Rolling Meadows Substation
Construction of a New Electrical Substation
including Grading, Drainage, and Surface Improvements
El Paso County, Colorado

EPC STORMWATER REVIEW COMMENTS
IN ORANGE BOXES WITH BLACK TEXT

115/12.47kV
COVER SHEET

DETENTION BASIN OUTLET STRUCTURE DESIGN

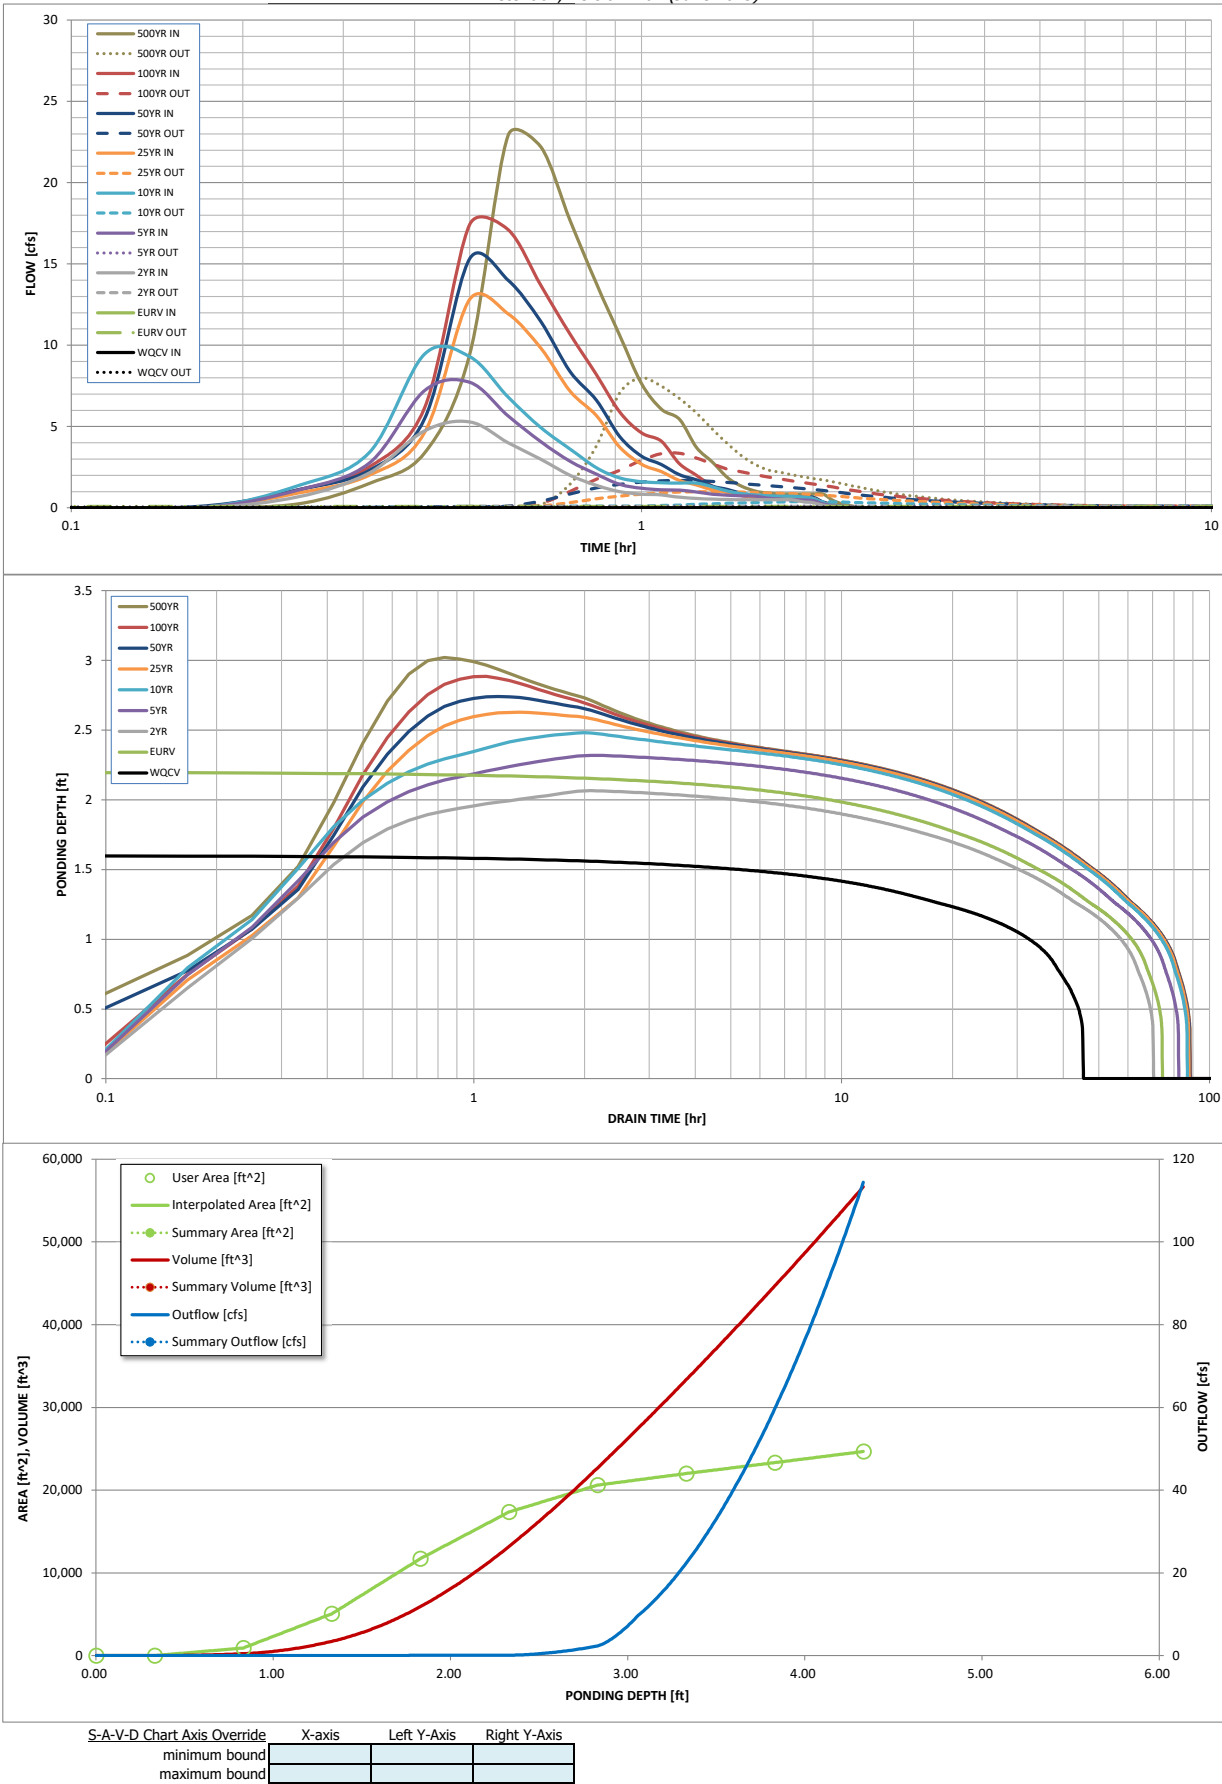
Provide restrictor plate detail.

Provide detail for restrictor plat, as shown on MHFD spreadsheet

ROLLING MEADOWS SUBSTATION
115/12.4KV
EDB-1 GRADING

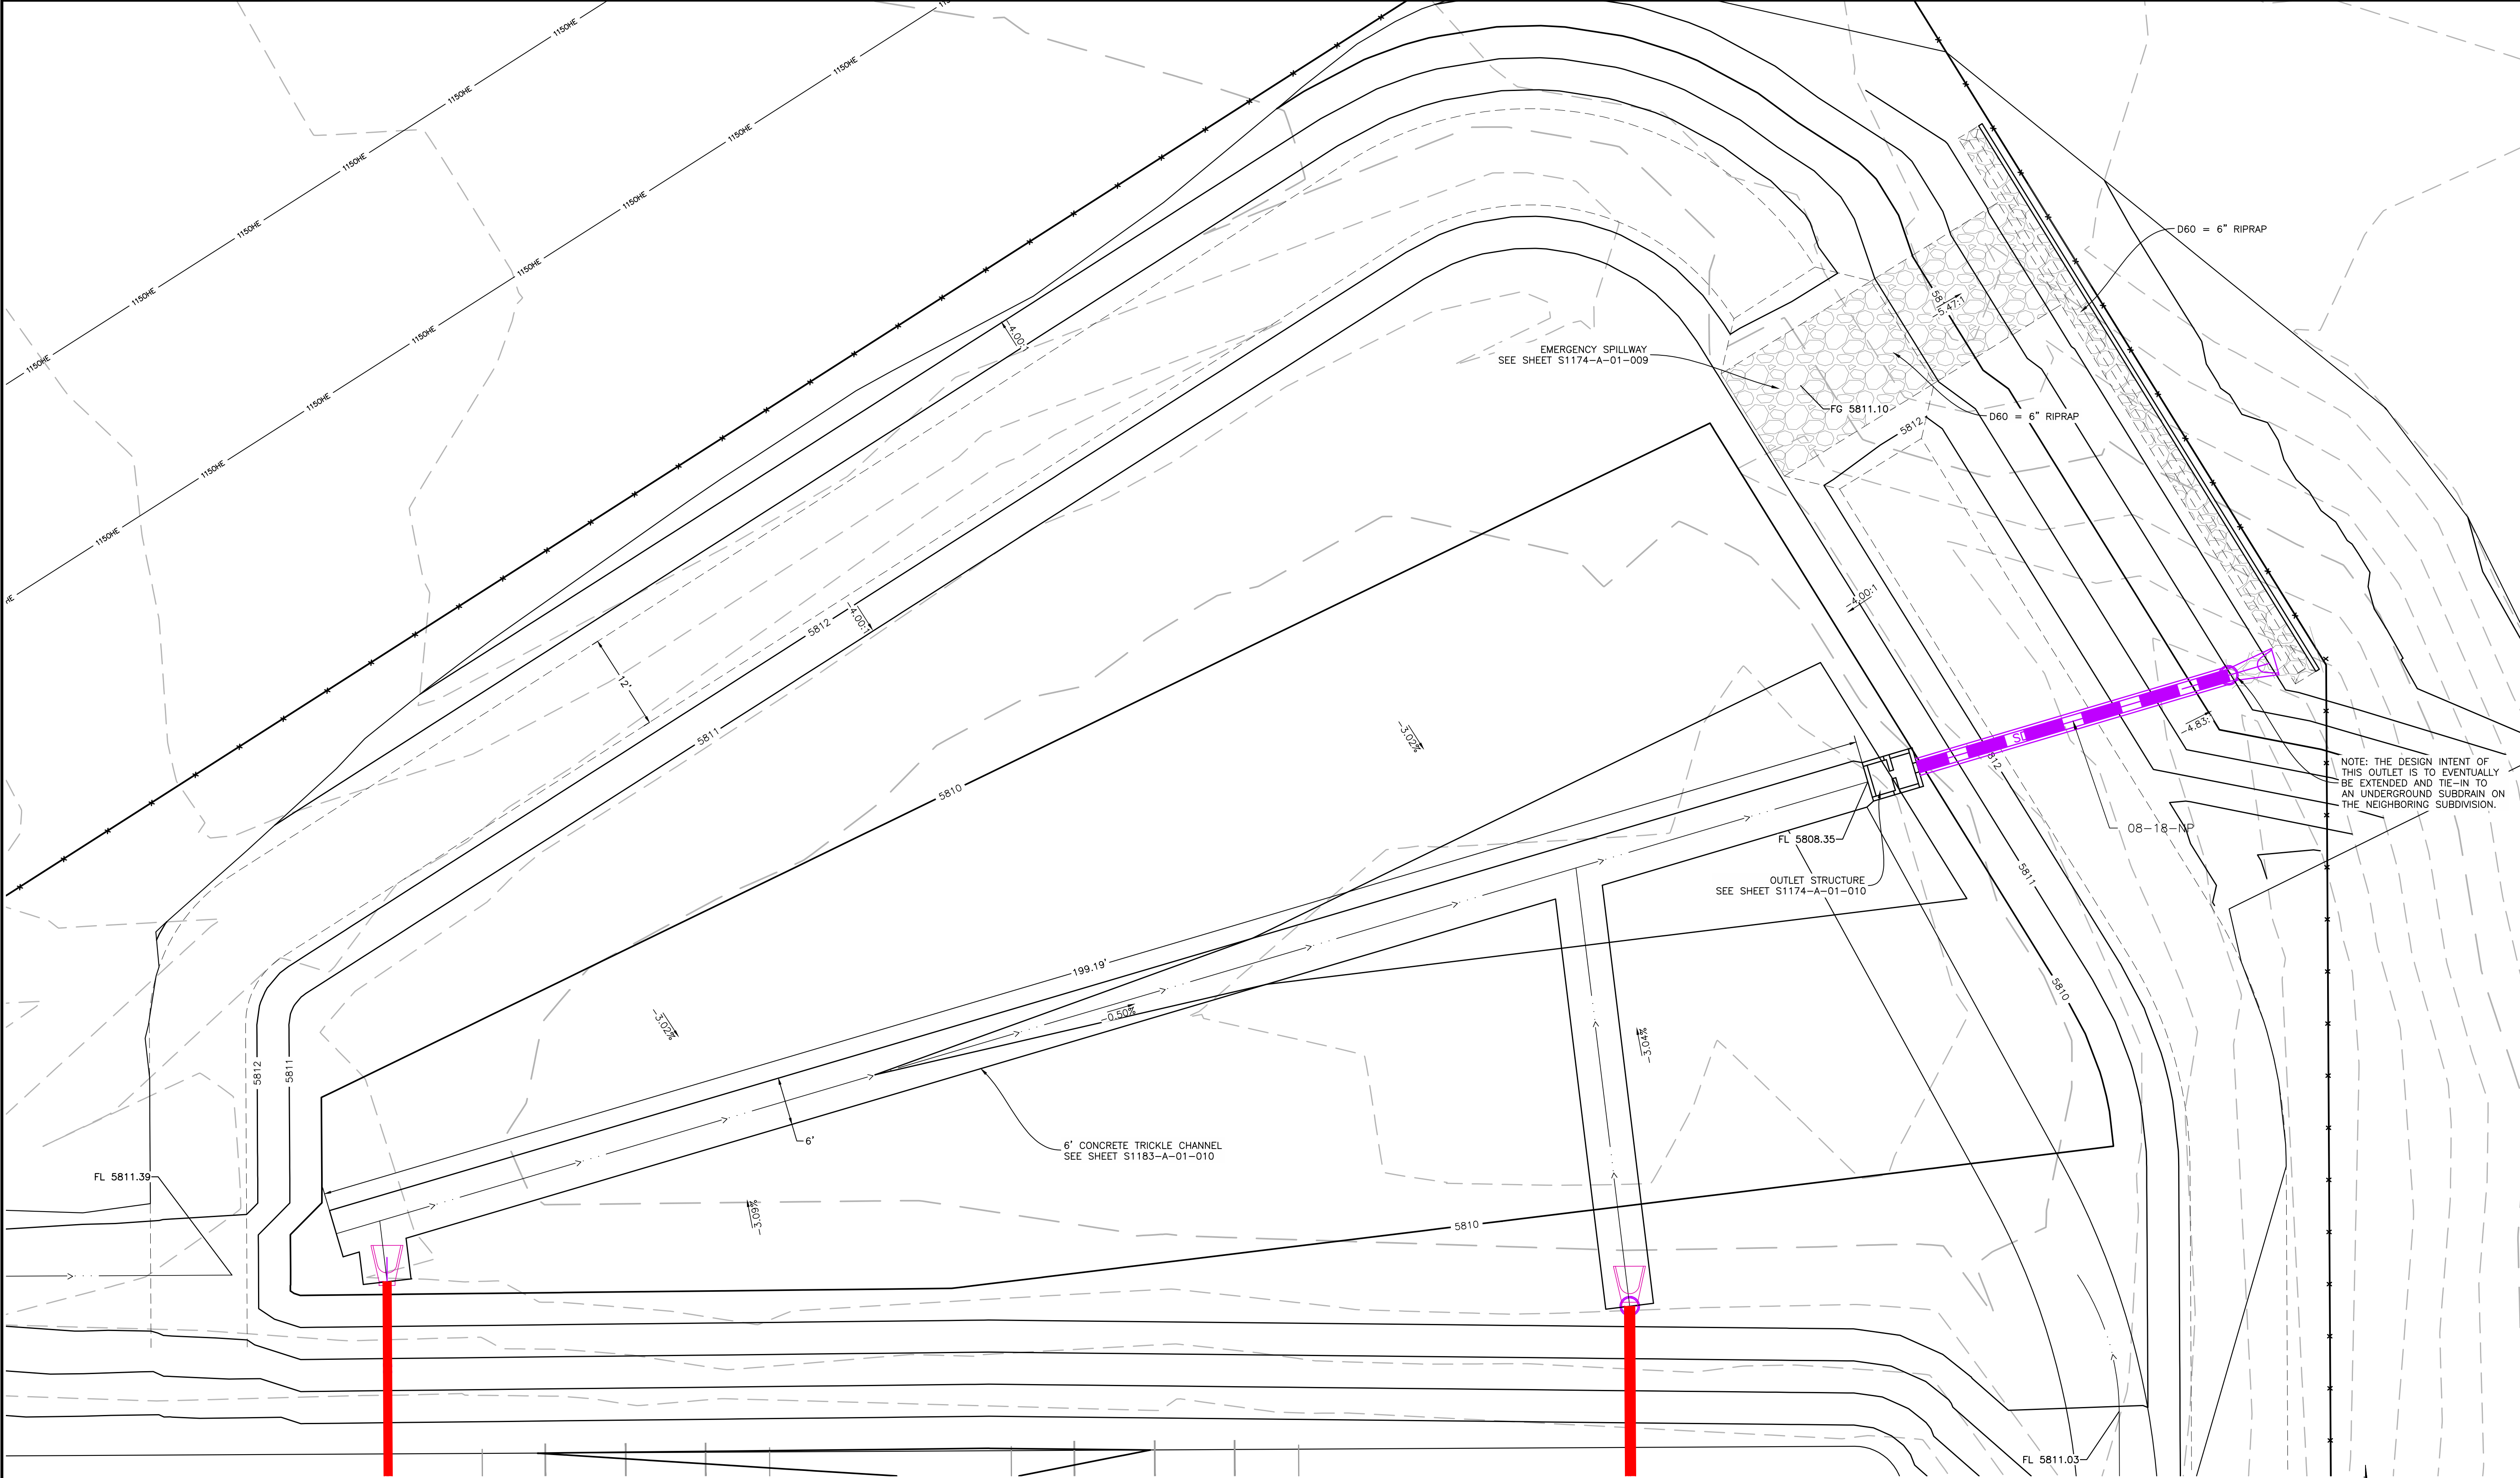
Show maintenance roadway in planview
